**Application Reference: 2025/0101**

**Site Address: 30 St Juliens Way, Cawthorne, Barnsley, S75 4ES**

This application seeks full planning permission for the erection of a single storey front extension to dwelling.

East Elevation 1:100

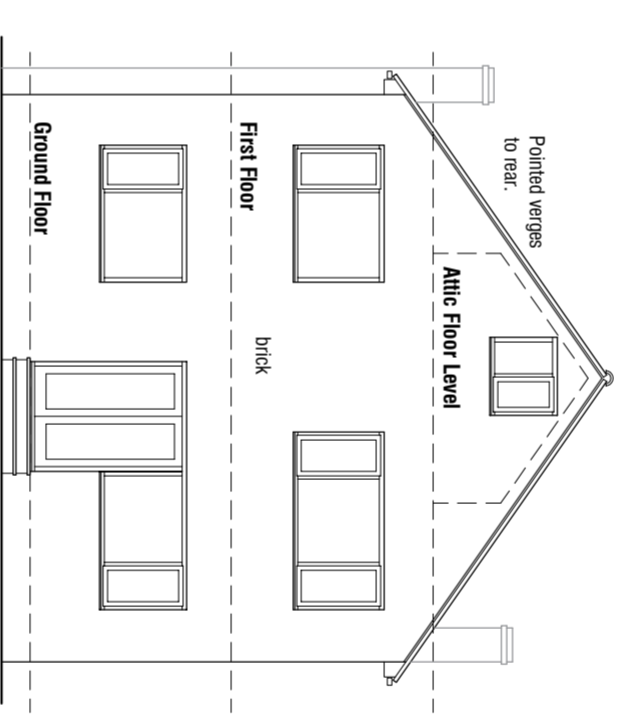
It is proposed to include a window within the eastern side elevation of the proposed extension, however it is not considered that it would lead to an increase in overlooking of the neighbouring dwelling to an unreasonable level given that the window would be located 1.3m from the

shared boundary, the area to the front of the property is not considered private and that the window would be located at 90 degrees to, and approximately 9m from the habitable room window located on the front elevation of the potentially affected dwelling.

Ground Floor Plan 1:50

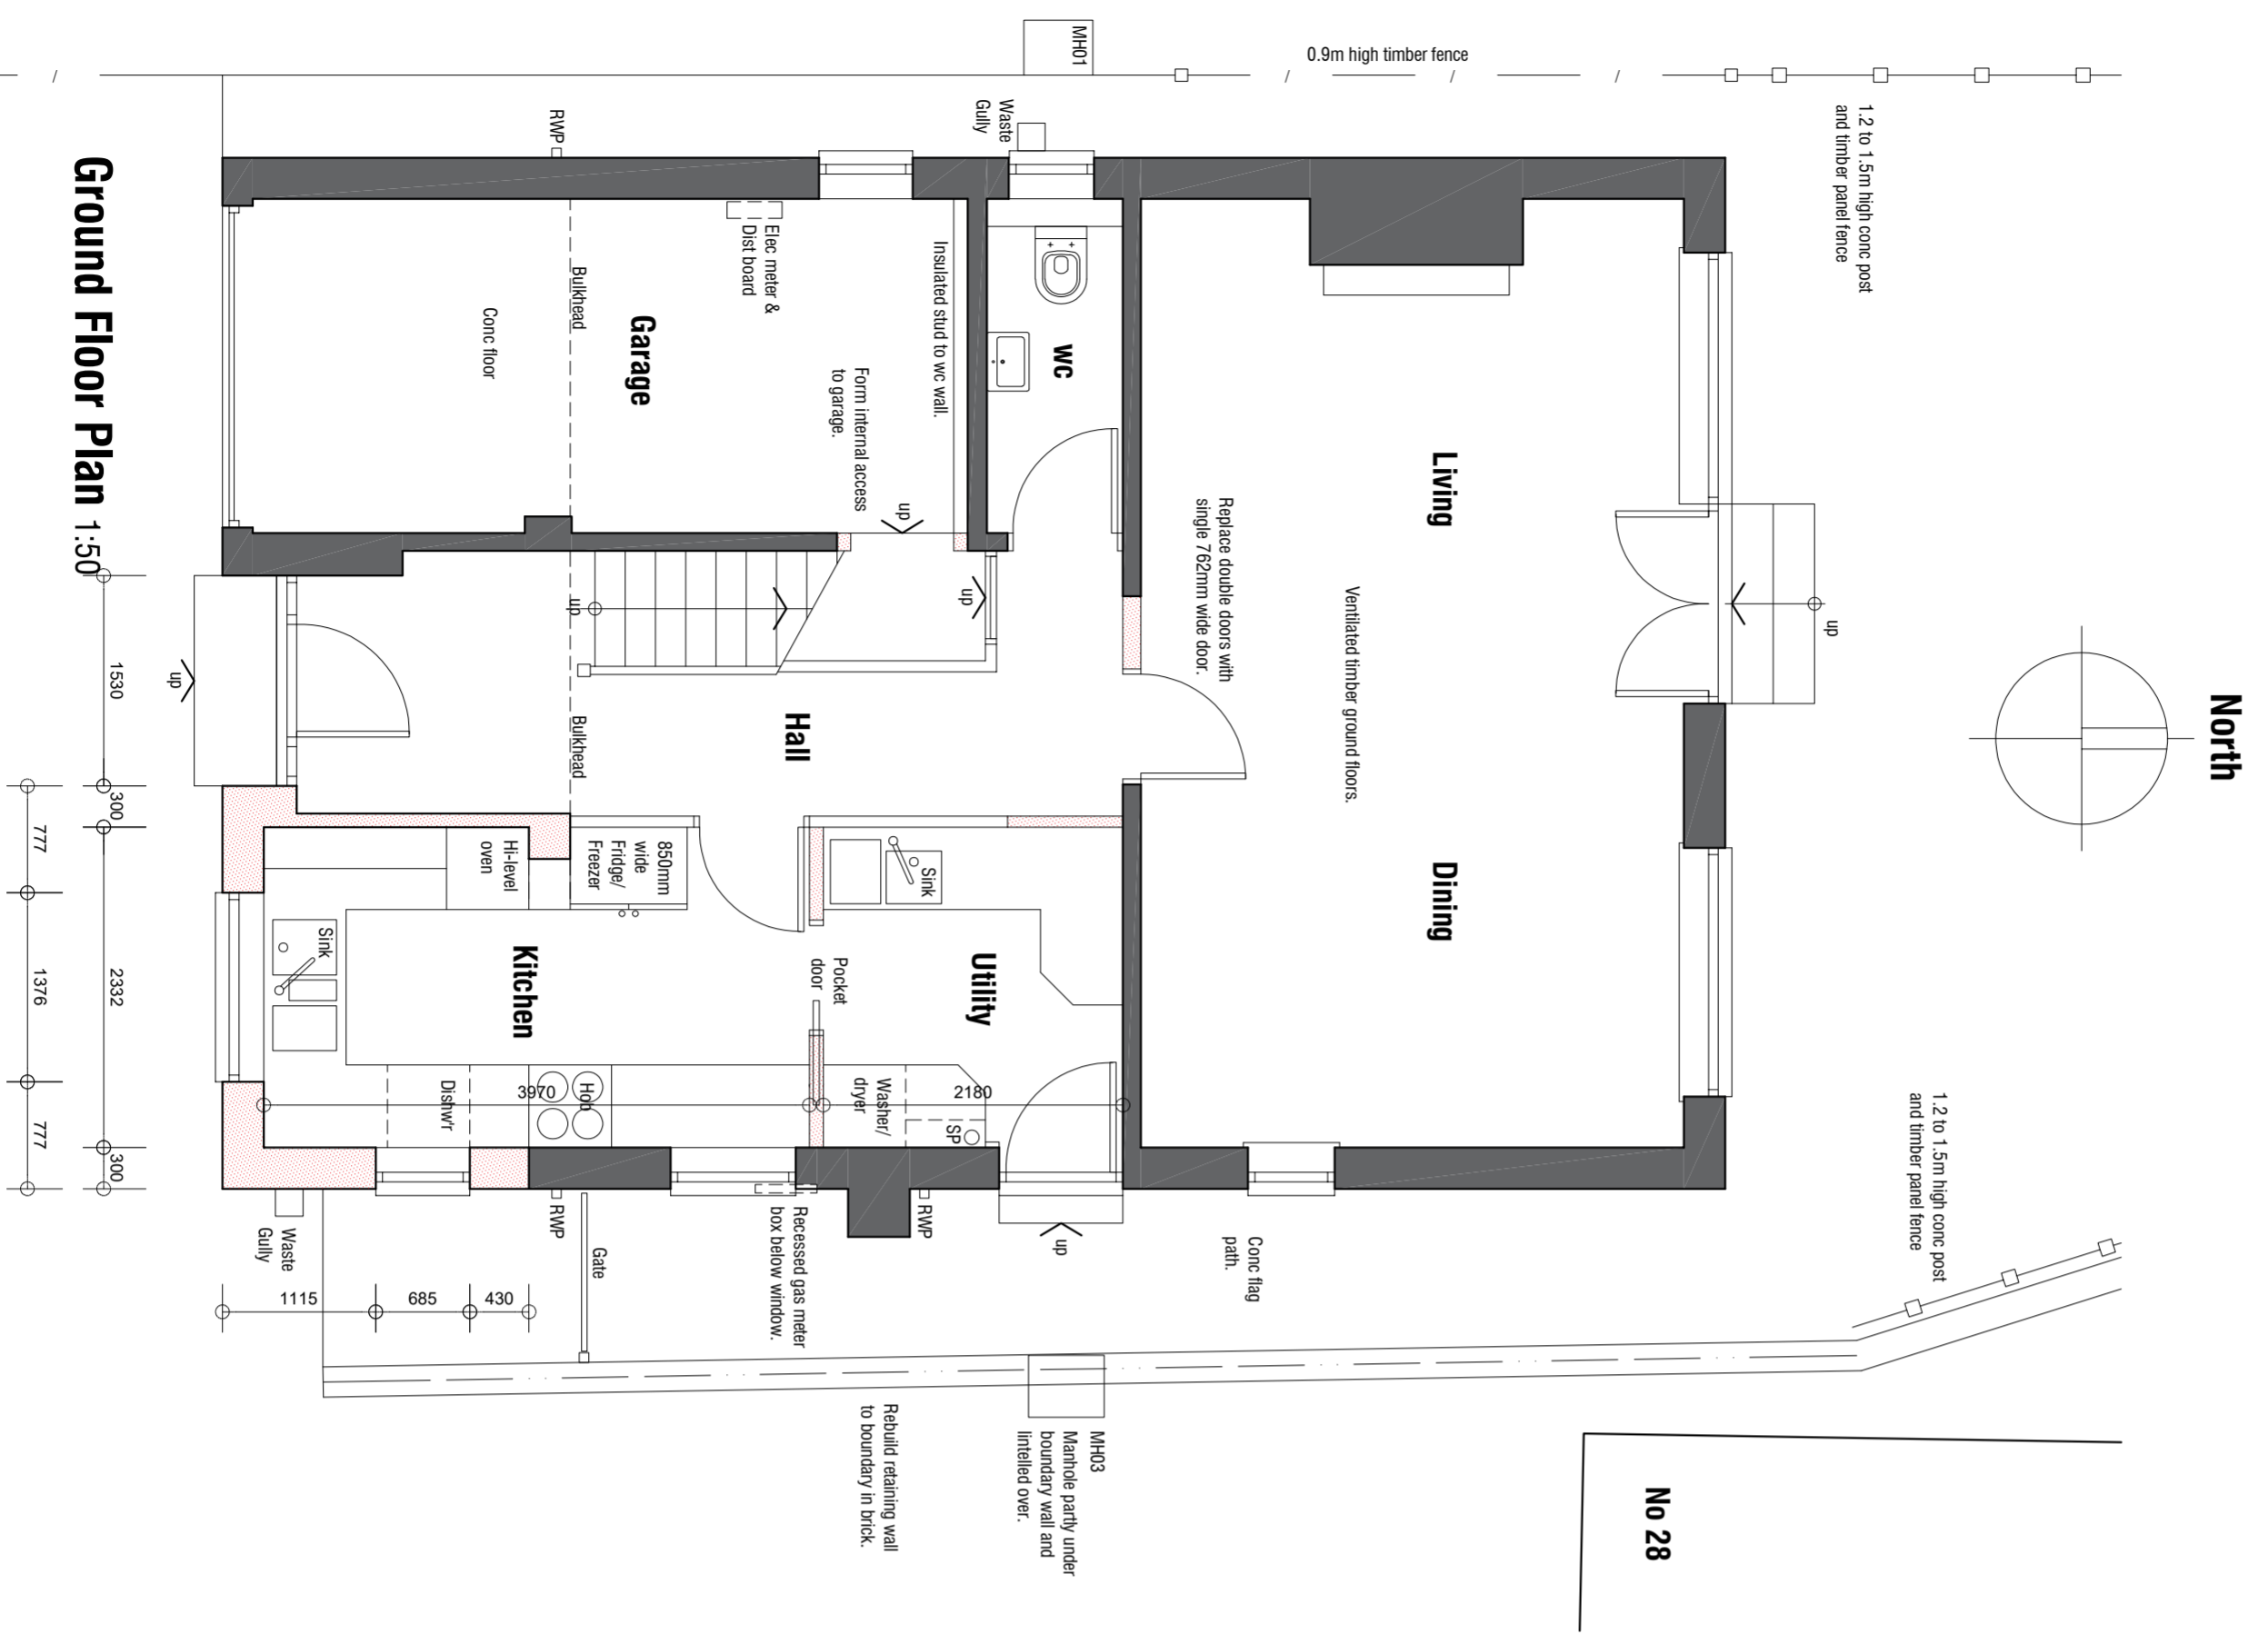
The applicant seeks permission for the erection of a single storey extension to the front elevation of the dwelling. The extension is to project 2.2m from the front elevation, extending 2.9m along it, infilling the existing forward projection. It is also proposed to alter the existing recessed porch to include a central gable feature.

The proposed extension is designed to reflect the original dwelling in terms of roof style and pitch and is to be constructed from materials which match the original dwelling. It is therefore considered that the proposed extension is acceptable in terms of visual amenity and in compliance with Local Plan Policy D1, which carries significant weight in favour of the application.

The erection of the front porch/kitchen extension is to be located on the front southern elevation of the dwelling. As the proposed extension is to not extend beyond the furthest projection of the existing integral garage, the proposed extension would not result in a detrimental impact on the property to the west, 32 St Julien's Way by means of overshadowing or loss of outlook.
